From: Bob Sharples
Sent: 29 July 2021 10:55
To: Planning
Cc: Thomas Darlington; Caroline Ford
Subject: App Ref: 21/02339/REM - Land adjacent to Bicester Road - Sport England Ref: PA/21/SE/CL/59276

Thank you for consulting Sport England in respect of the reserved matters relating to the Reserved Matters application for 14/02121/OUT, Phase 1 Development of 500 dwellings, landscaping, new vehicular, cycle and pedestrian access routes and other operations.

With regard to the submitted reserved matters, Sport England would like to make the following representations on condition 8 (site wide illustrative master plan):

Outline Use and Amount Parameter Plan | Not to scale

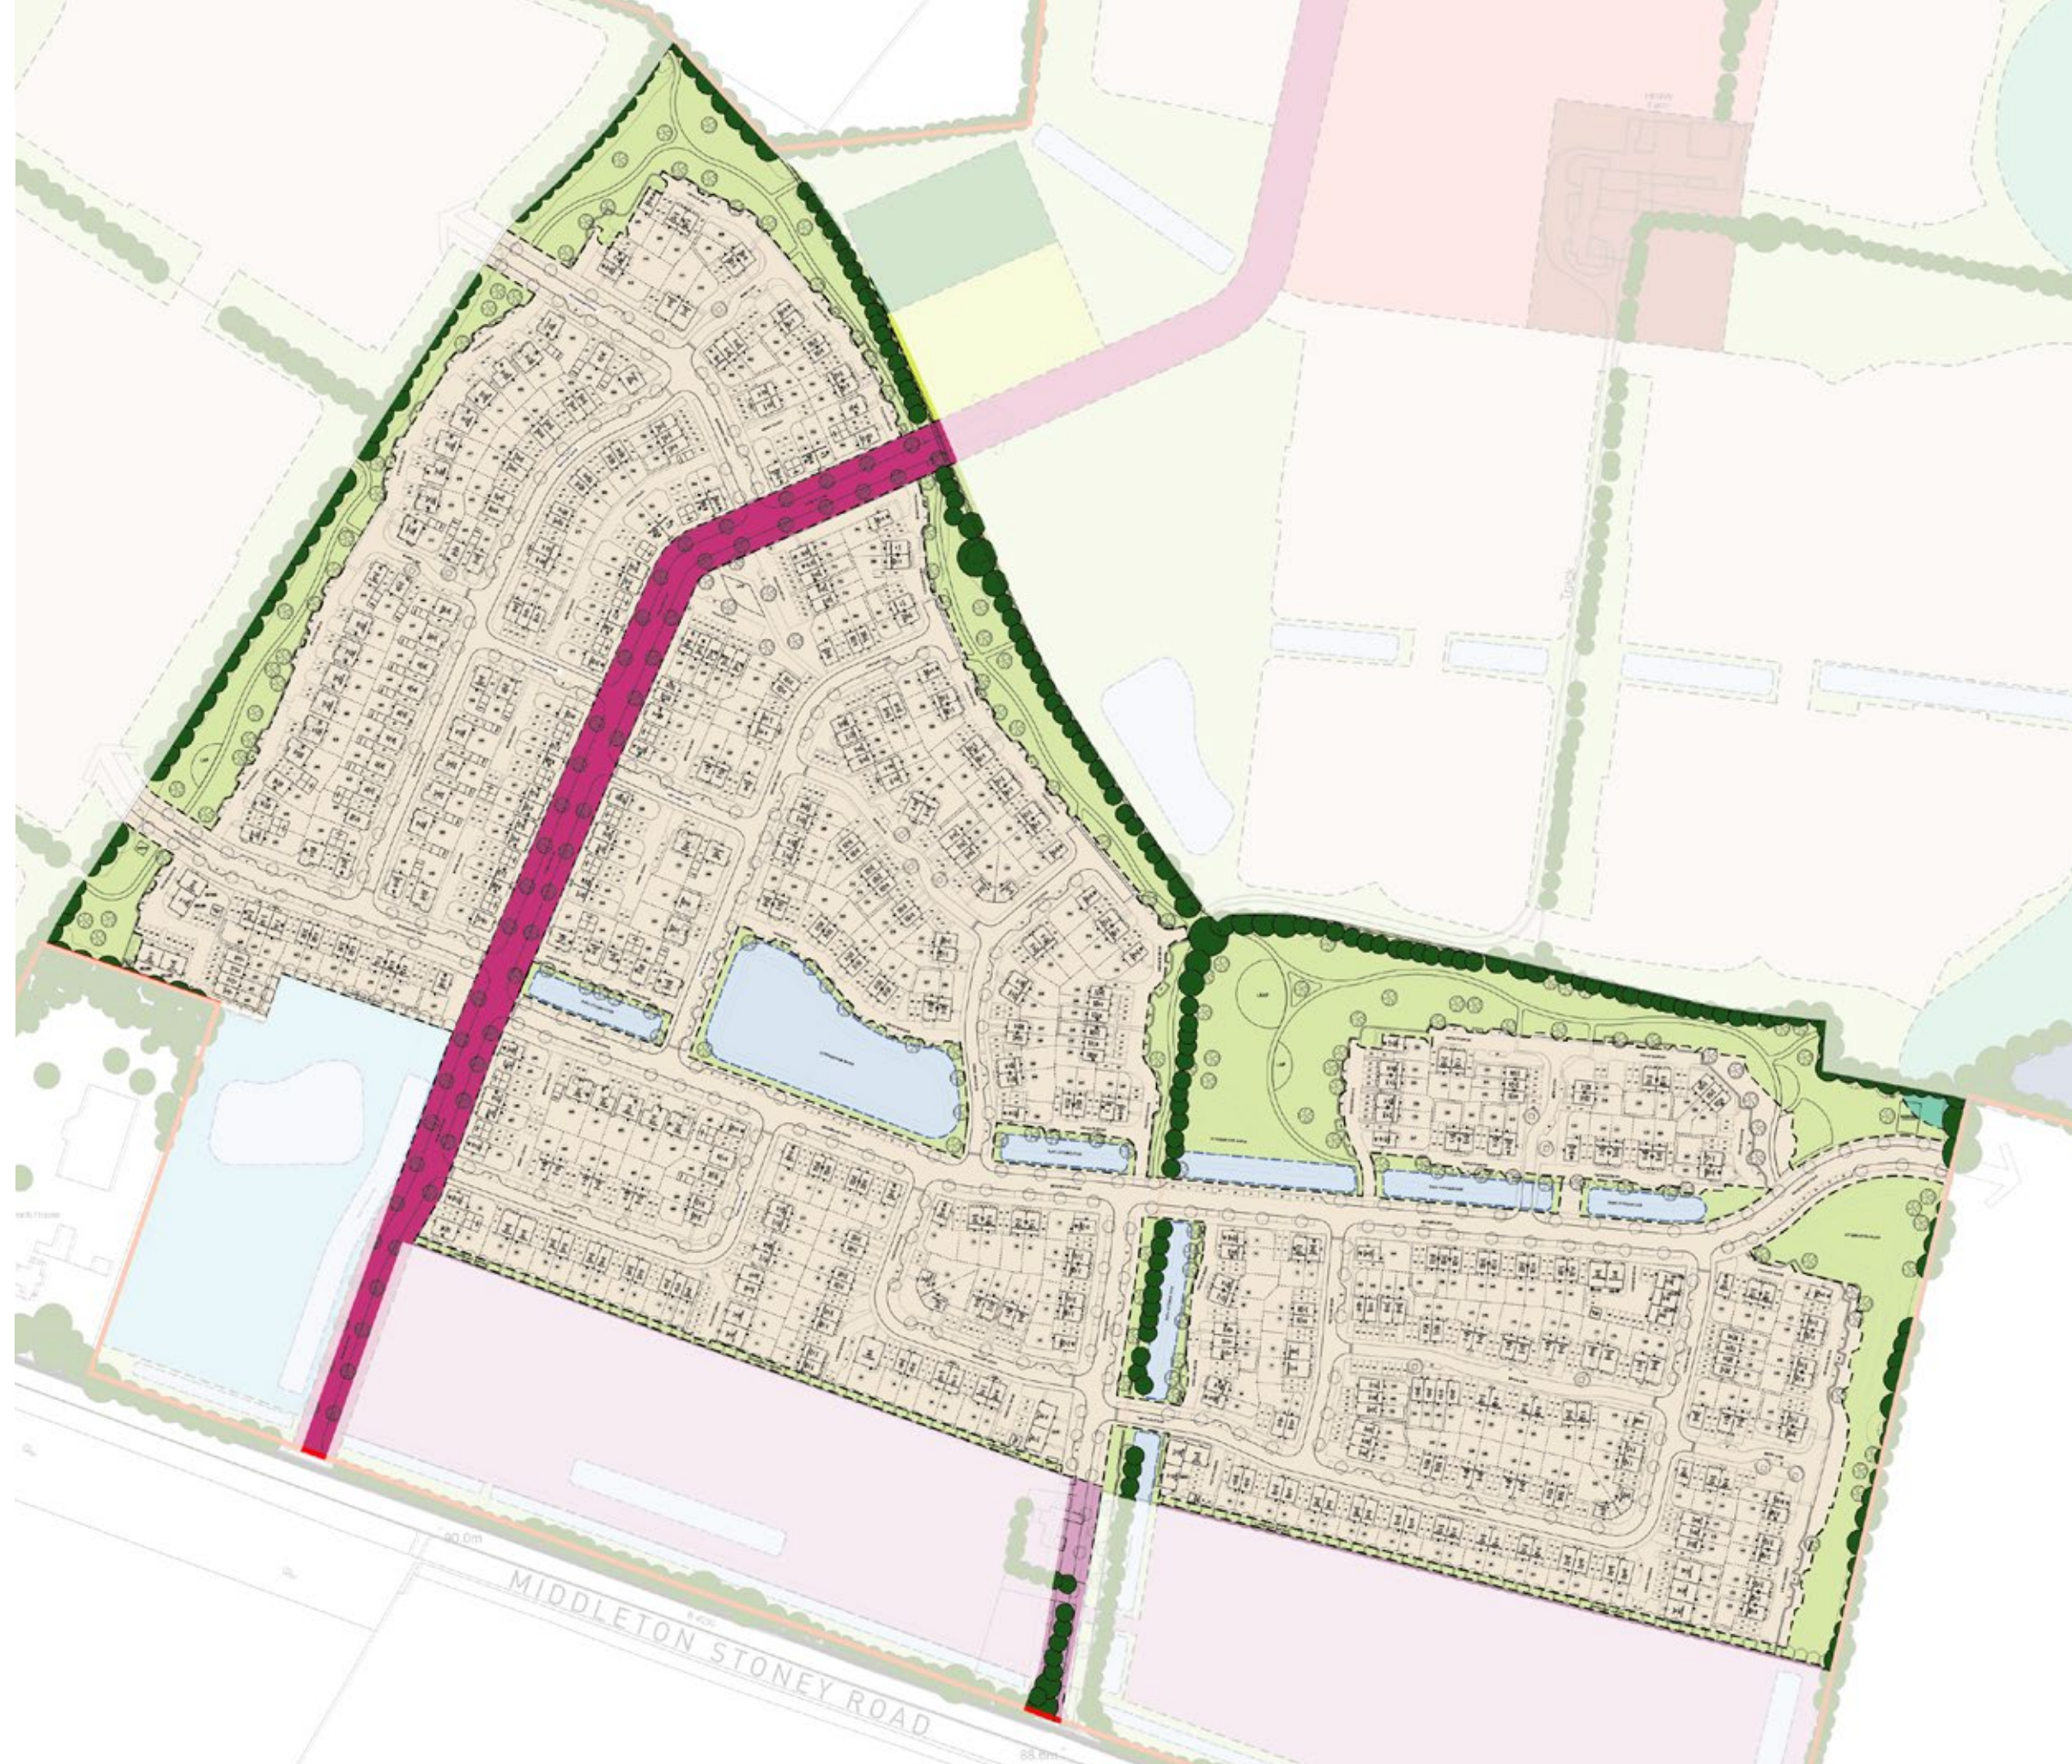
1. The proposed playing field layout is too tight as can be seen below:

Some of the pitch run off areas are in the proposed foliage and some have the green infrastructure pedestrian and cycle routes are going across the pitches.

2. There is no details of the proposed pavilion – it is therefore difficult to say where or not it is the right size;
3. Ditto the car park;
4. There are no details who will be managing the site.

Sport England wishes to object to the details submitted, for the following reasons: The layout for the playing fields does not appear to be workable and there is insufficient detail to determine on whether or not the supporting facilities are the rights size.
